# **SUPPLEMENTARY RESPONSE TO SUBMISSIONS**

Exhibited Phases 2 & 3 Lindfield  
Learning Village SSD 8114

**NSW DEPARTMENT OF EDUCATION**

26 August 2020

3D AT ELEVATED STRUCTURAL ROAD
N.T.S. (FOR ILLUSTRATION PURPOSE ONLY)

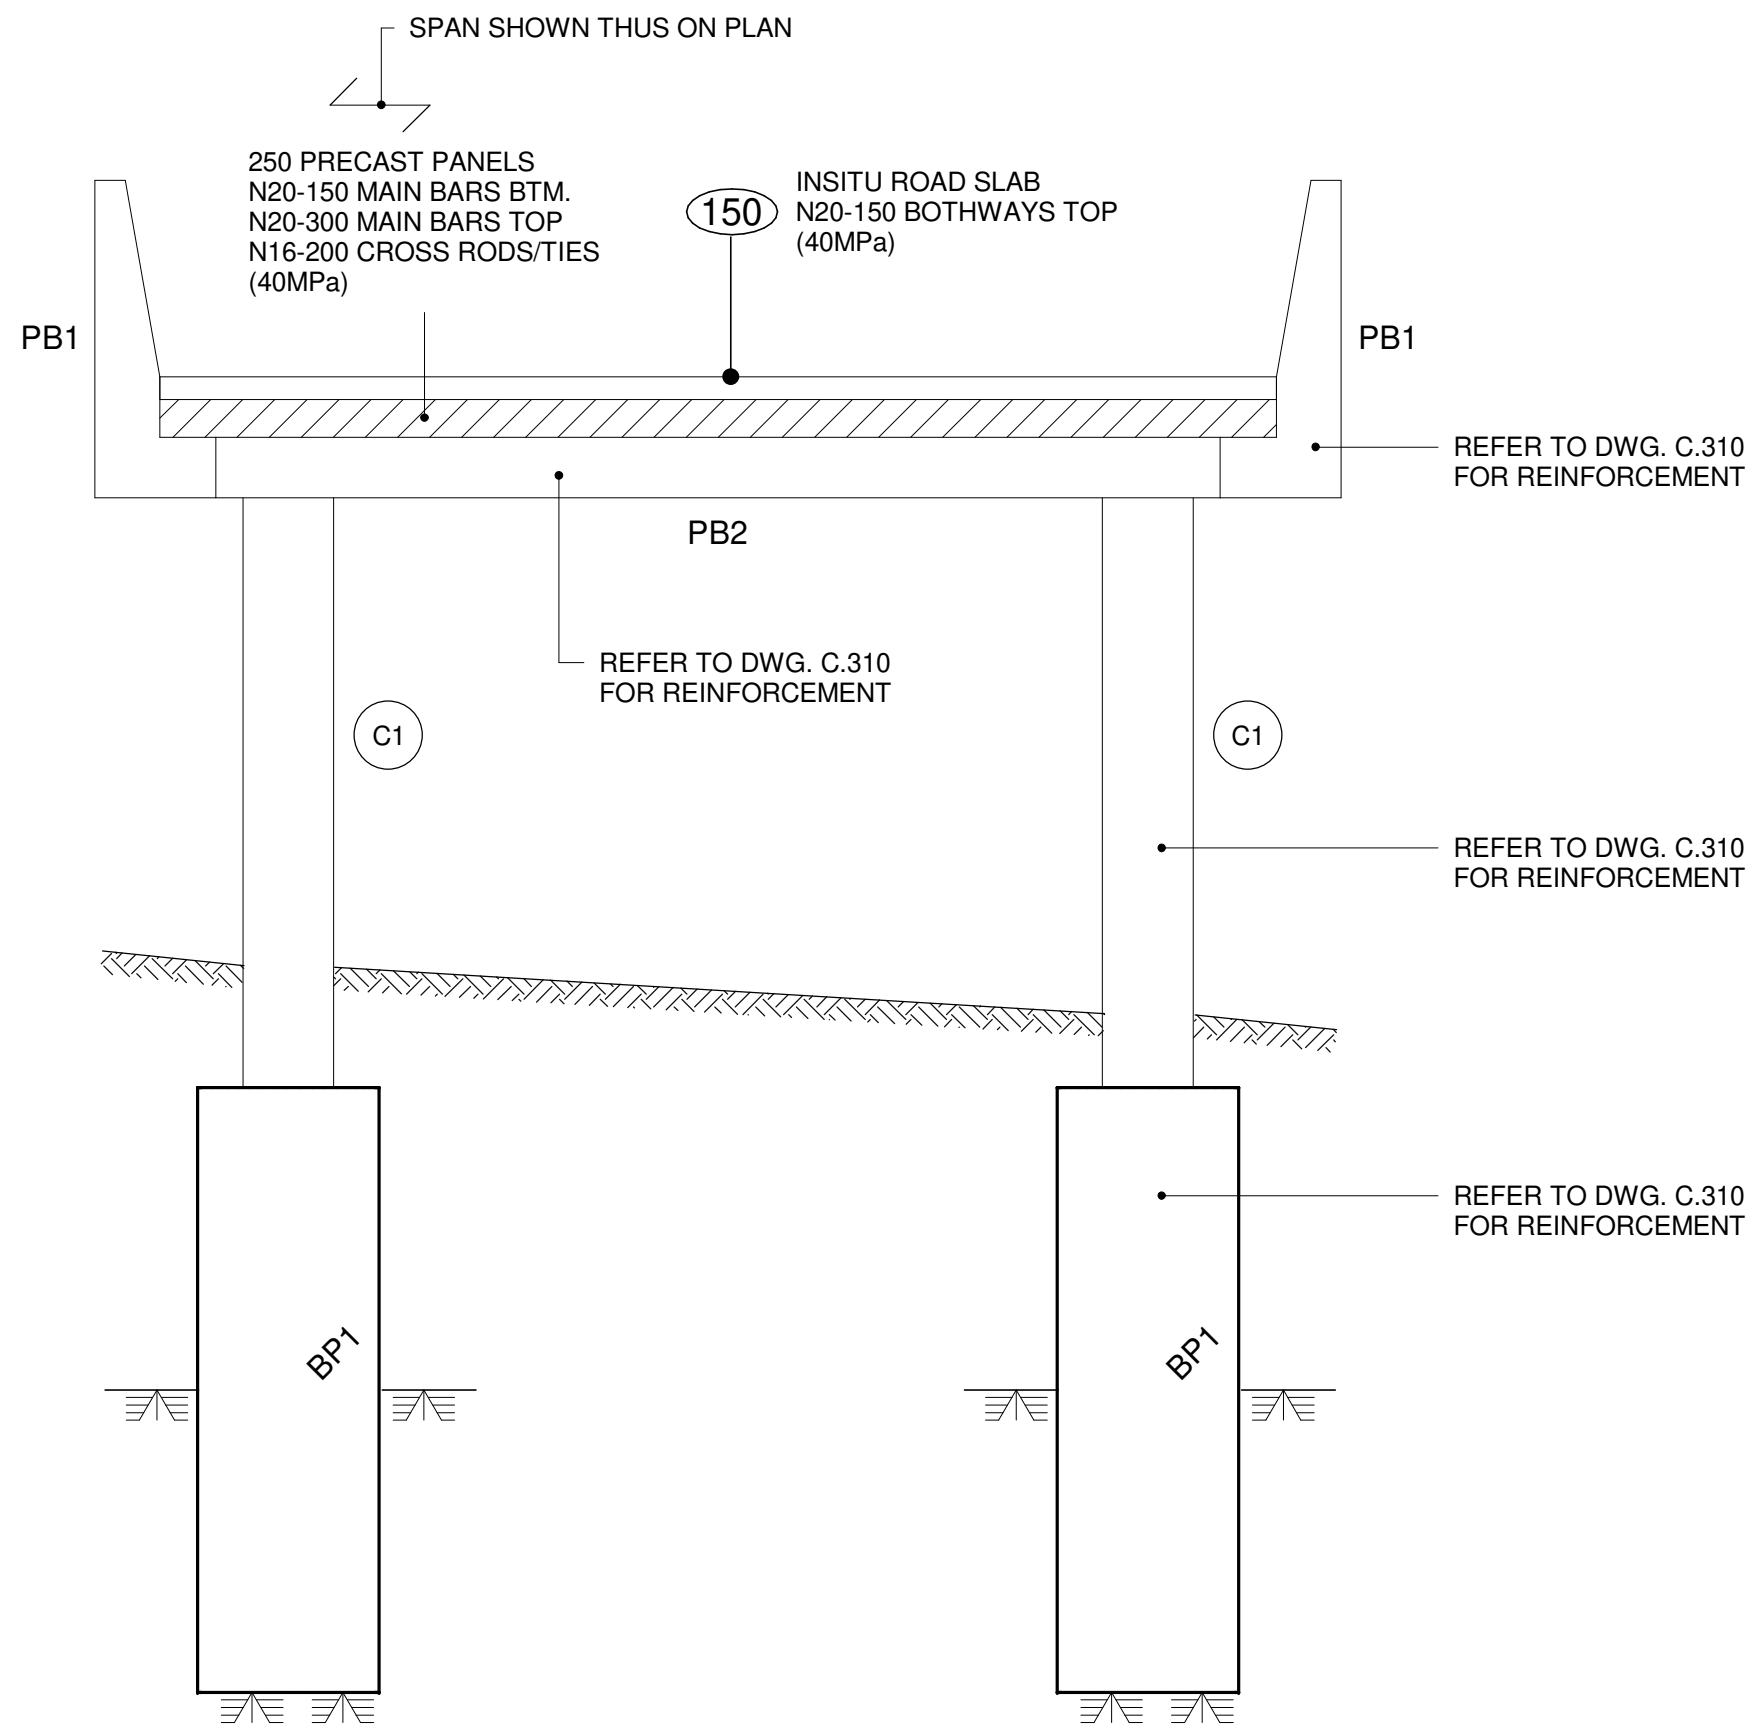
<b>B.</b>	<b>Road and Safety</b>		
B1	<p>The RtS must provide an updated road safety audit report and construction management plan that includes consideration of the potential operational conflicts for the following areas (but not limited to):</p> <ul style="list-style-type: none"> <li>- the operation of the existing Phase 1 parking and pick-up and drop-off facilities during the construction of the loop road and other construction activities.</li> <li>- potential safety risks and hazards caused by the active play space linemarking on the area to be used for parent pick-up and drop-off at the end of the loop road (as detailed in landscape plan LA-2-0006).</li> </ul>	<p>A road safety audit was completed on the concept design. The issues raised in the audit were noted and mitigations incorporated into the ongoing detailed design process. Management mitigations for the active play space and drop off pick (DOPU) dual use have been developed to mitigate these hazards. This audit report is included in the revised Traffic Response.</p>	Refer <b>Appendix E</b> - Transport Response.

Figure 3 – APZ distance required to achieve 10 kW/m<sup>2</sup>.

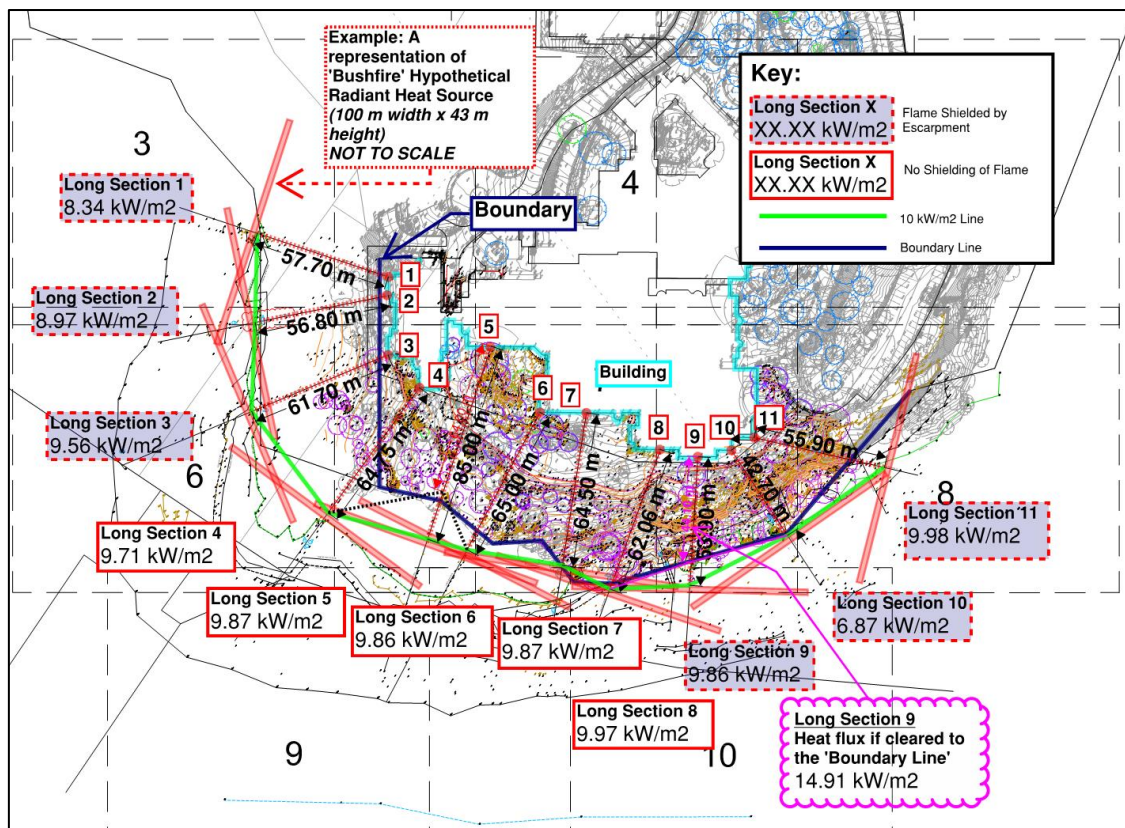
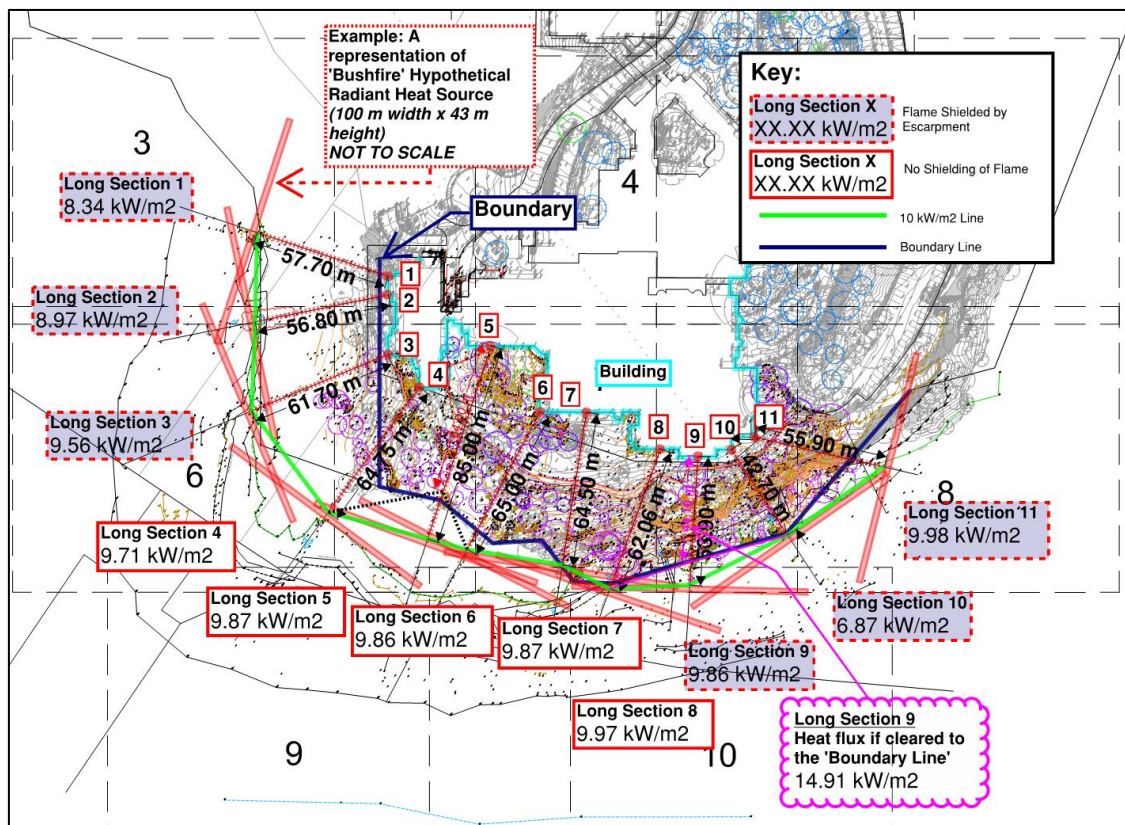
RFS			
B. Review of Detailed Radiant Heat Modelling			
B1	The basis for using reduced fire temperatures for radiant heat flux modelling needs to be established, demonstrated and documented to be appropriate.	The flame temperature at different heights is calculated using the correlation derived by B. Mike in 2010 for dry eucalypt fires, in order to develop a more precise flame temperature than an average temperature across an entire flame height. The basis and its justification is described in Section 7.4 of the SGA Report 2018/321 R5.0. This basis is considered appropriate as it was developed for free-burning turbulent flames involving comparable fuel loads (NSW bush), and the data showed no strong deviation bias and was hence considered a good representation of realistic temperatures.	Refer to Fire Bushfire Design Engineering Report – <b>Appendix G</b>
B2	Flame length should be addressed as to whether flames would be expected to impinge on building elements.	The flame height was 43 m from base to tip. The closest APZ distance was 42.7 m, where the flaming region however, would start at the base on an ~11 m escarpment, leaving the school exposed to less than 32 m of flame height at that point. Therefore, flame impingement was considered unlikely.	Refer to Fire Bushfire Design Engineering Report – <b>Appendix G</b>

B3	Should flame lengths indicate impingement on building elements then the design needs to accommodate this issue.	Flame impingement is considered unlikely, nevertheless, all elevations are constructed to BAL-FZ, which is intended to withstand direct flame impingement.	Refer to Fire Bushfire Design Engineering Report – <b>Appendix G</b>
B4	The radiant heat loads on buildings need to represent all exposures and should include Long Sections 1 to 11.	All elevations are BAL-FZ so onerous heat fluxes greater than 40 kW/m <sup>2</sup> have been designed for. The flame width used to model radiative heat flux to the school in SGA Report 2018/321 R5.0 from any point is 100 m wide (which is often wider than the width of bush that that particular	Refer to Fire Bushfire Design Engineering Report – <b>Appendix G</b>
